Department of Planning
Director - Coastal Assessments
GPO Box 39
SYDNEY NSW 2001

Your Ref: MP 05_0129

**Request for environmental assessment requirements for 10//1071628,
1//1089778, 2//607602 & 95//1126227 Lakes Drive & North Boambee Road North
Boambee Valley 2450**

The service is not in a position to properly assess the application as submitted by Department Of Planning – Coastal Assessments on the basis of the information provided. The following will need to be provided for further assessment:

PROJECT TITLE
LAKES DRIVE
NORTH BOAMBEE, COFFS HARBOUR
DRAWING TITLE
PROPOSED SUB DIVISION - STAGE 1
INDICATIVE COUNCIL DCP BUILDING ENVELOPES

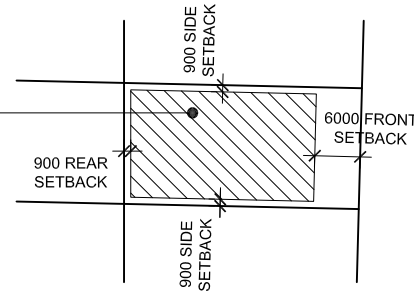
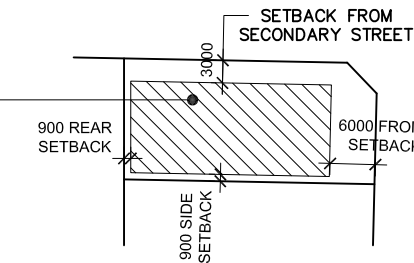
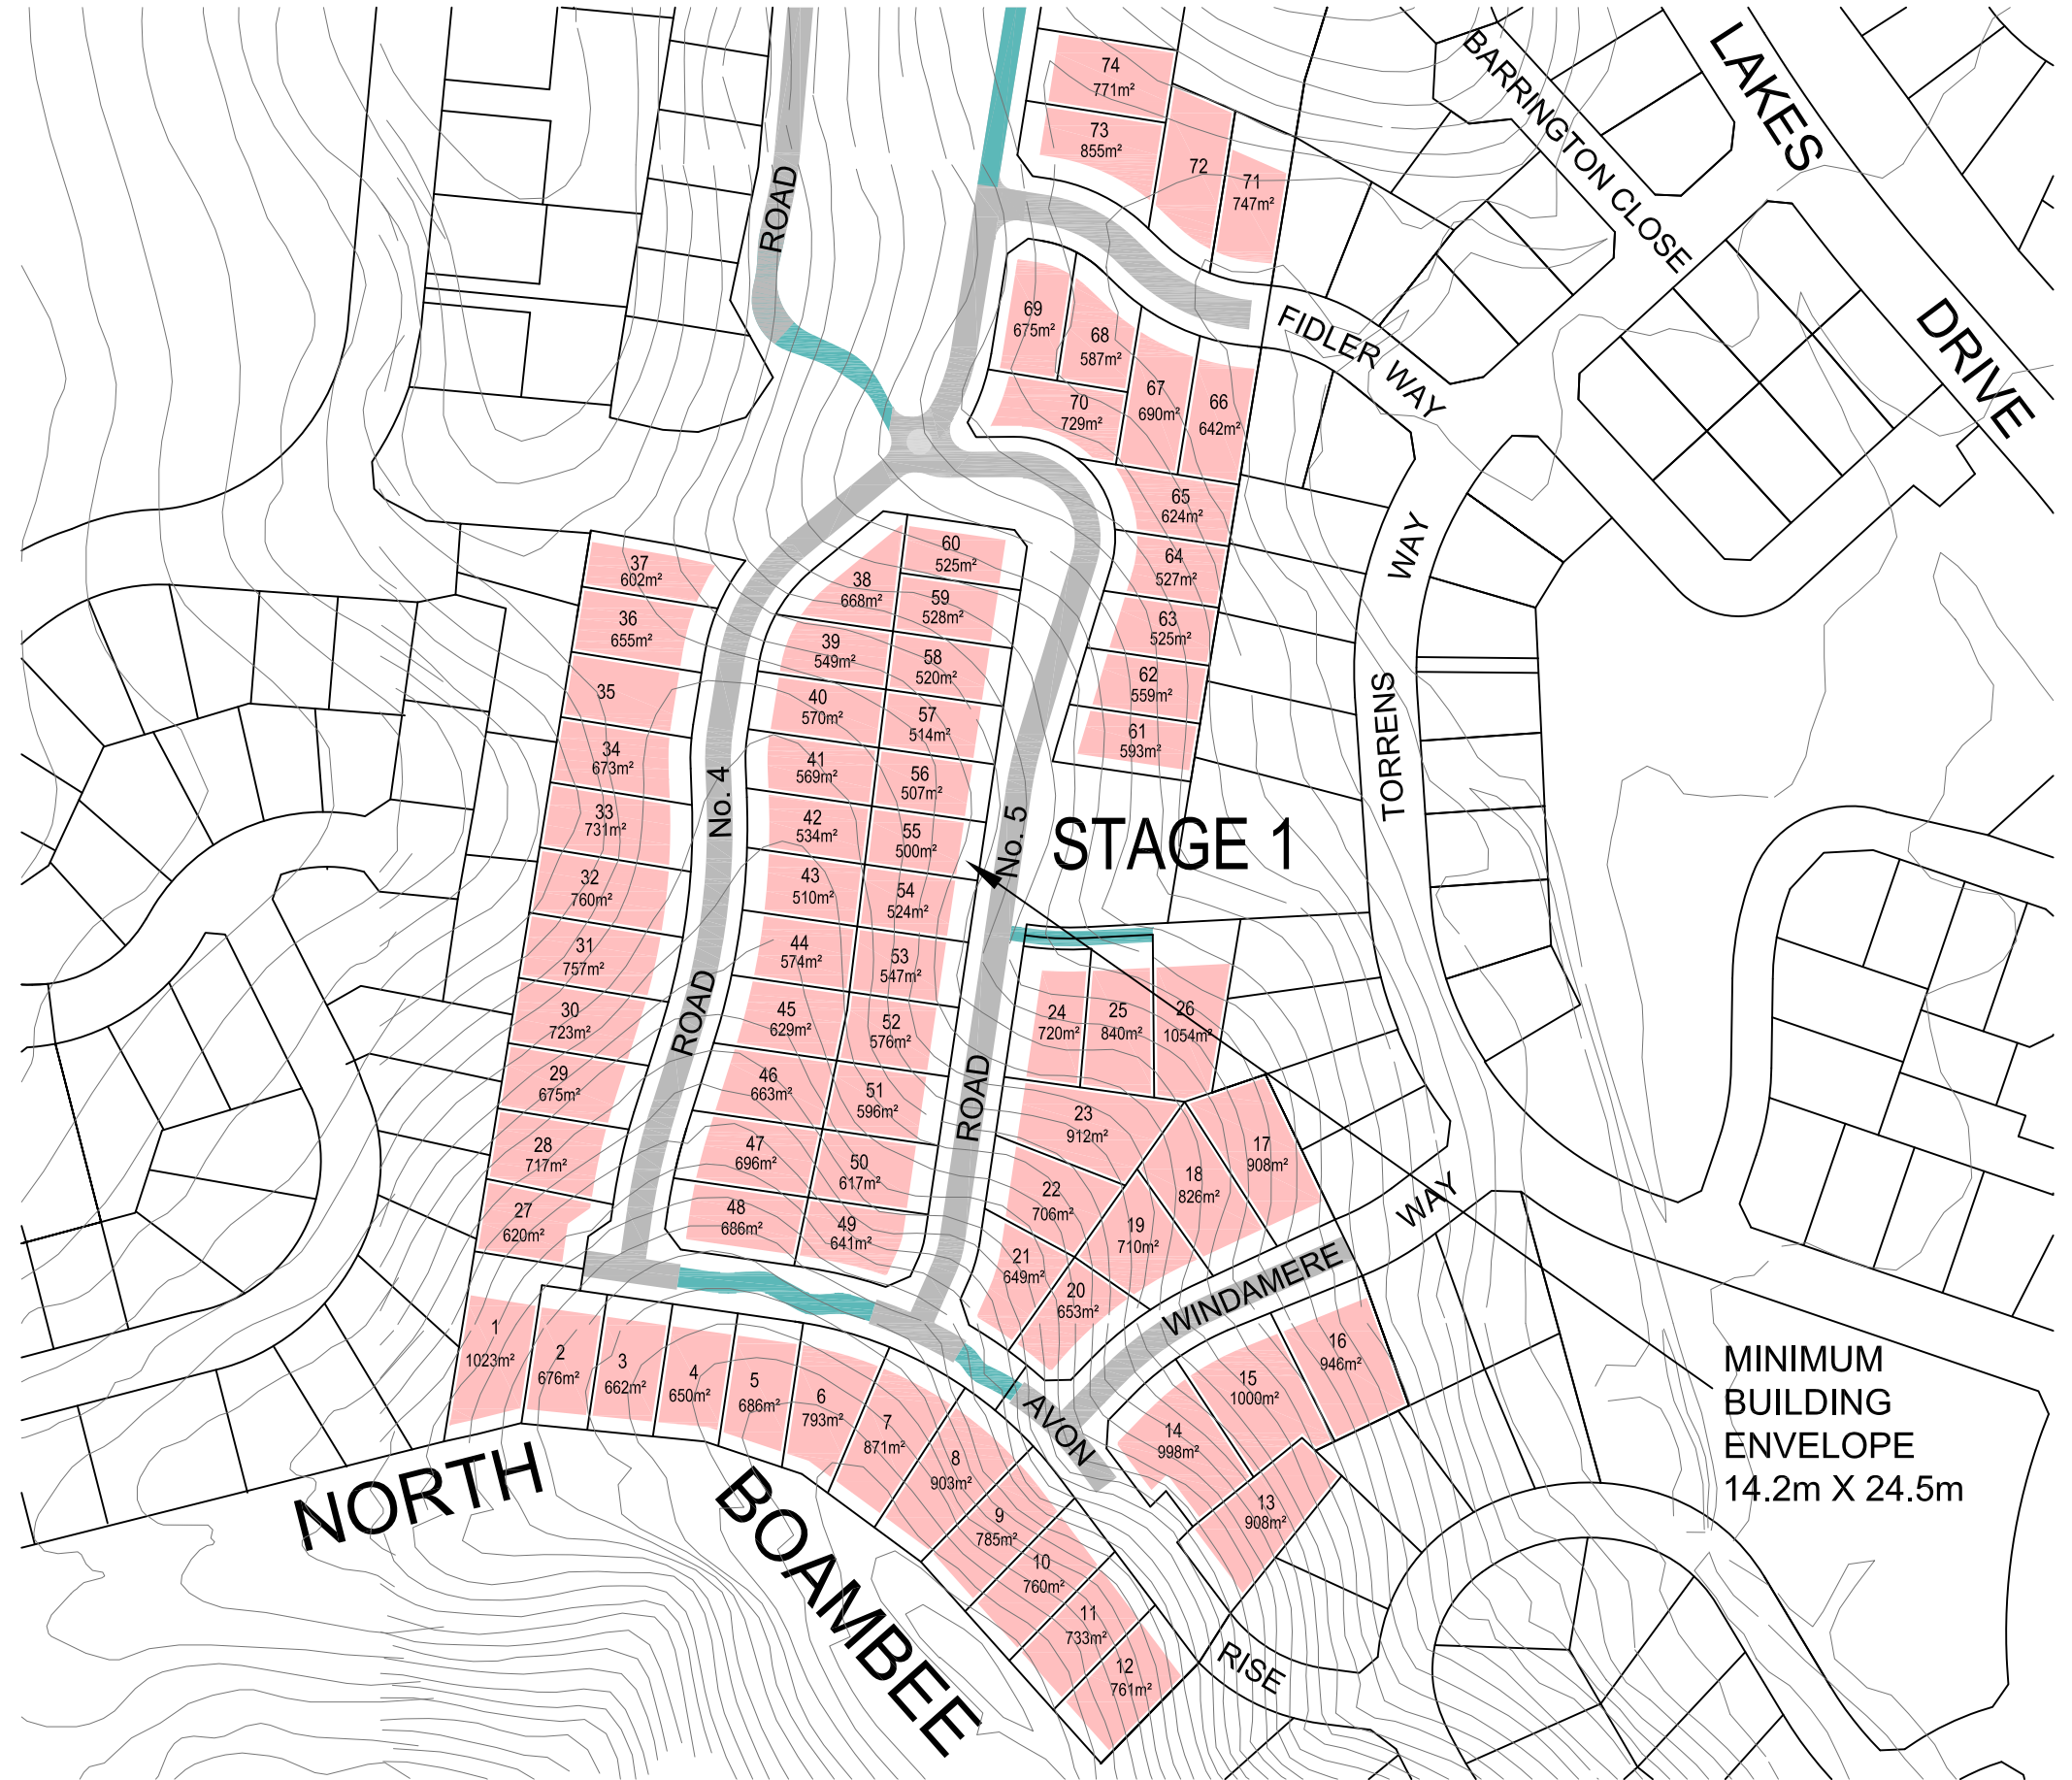
1. The proposed building envelopes for Lots 37, 61, 79, 149, 150 and 151 as indicated in the Bushfire Report prepared by Australian Bushfire Protection Planners numbered B07602 and dated 25.6.2008 do not support the required asset protection zones as per Table A2.5 of '*Planning for Bush Fire Protection 2006*'. The applicant is requested to submit further details demonstrating how proposed building footprints and appropriate asset protection zones required by '*Planning for Bush Fire Protection 2006*' can be achieved within the proposed subdivision.

Figure 8 – Asset Protection Zones to Lots 1 – 86

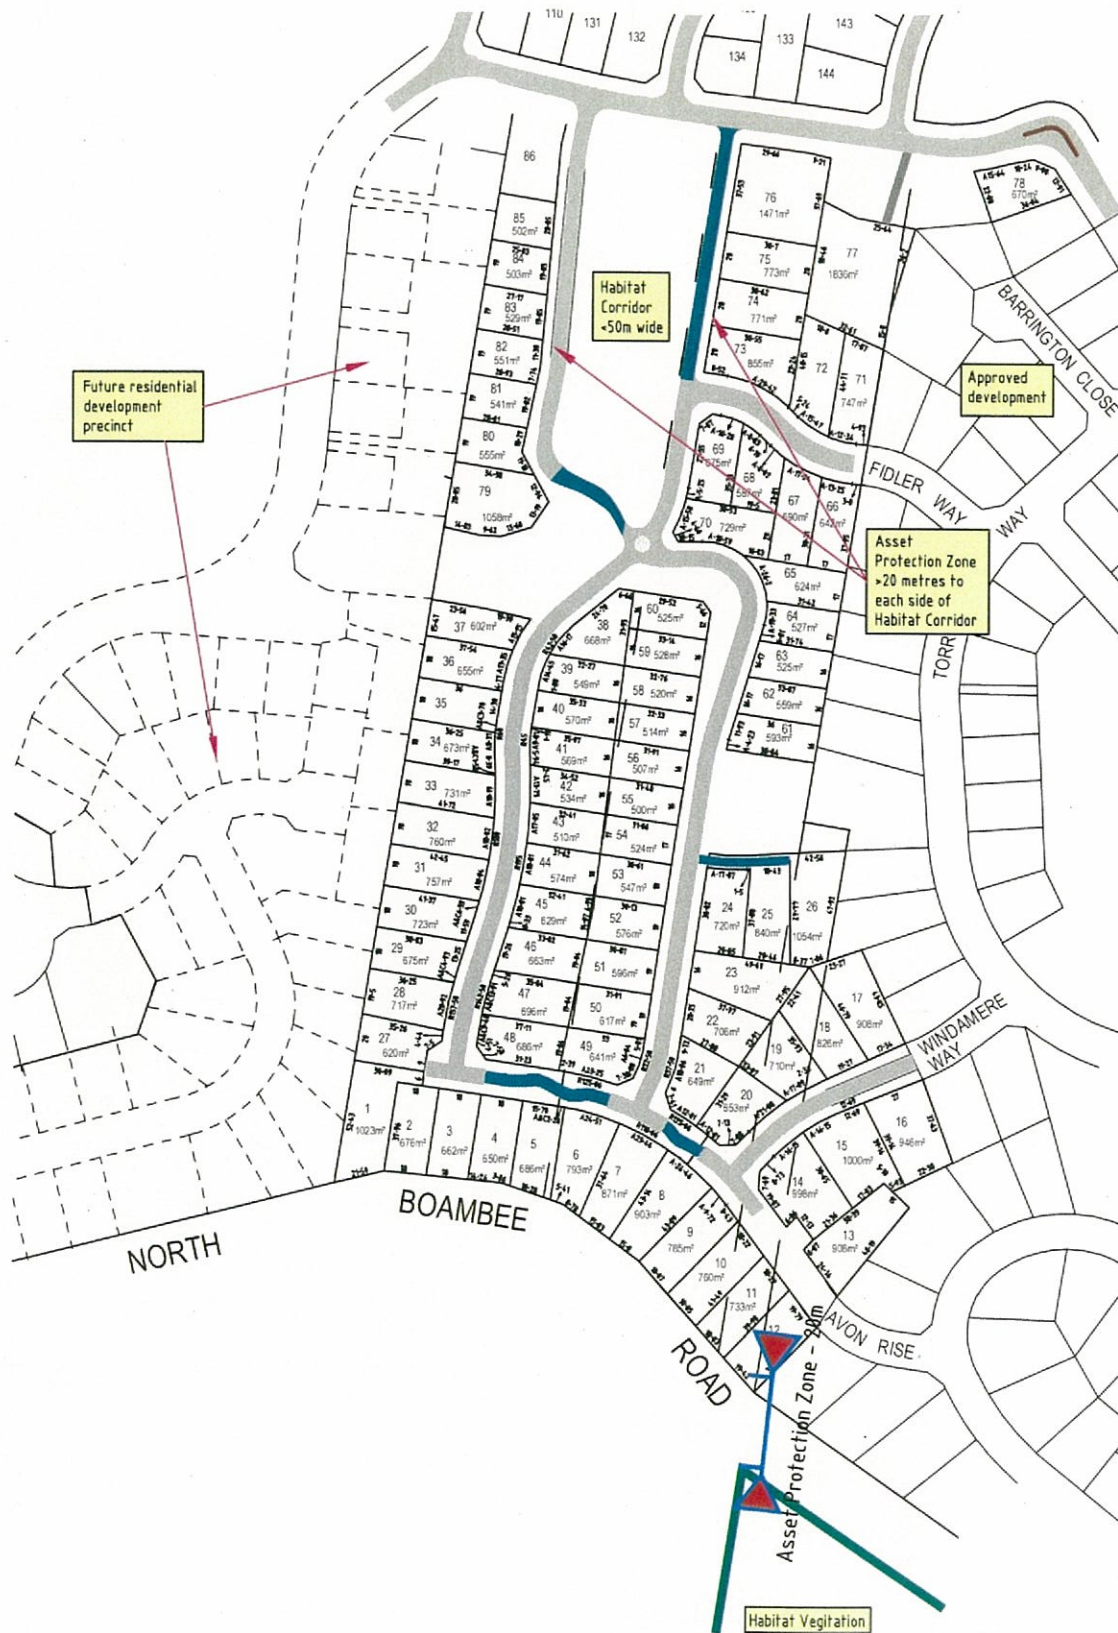
2. The Bushfire Report identifies that there is 'likely' to be development of lands adjoining proposed Lots 1, 27-37, 79-86, 167 and 168. The RFS cannot accept proposed works as circumstances may change and the development may not proceed. In addition, only in extenuating circumstances can the application of asset protection zones (APZ) on adjoining land be permitted (i.e. creation of an easement under section 88B of the '*Conveyancing Act 1919*'). Therefore the application of appropriate APZ (on the adjoining land) applied to the full length of the respective boundaries shall be provided and secured under an easement arrangement. The RFS requires that the applicant demonstrate that this proposal has the adjoining property
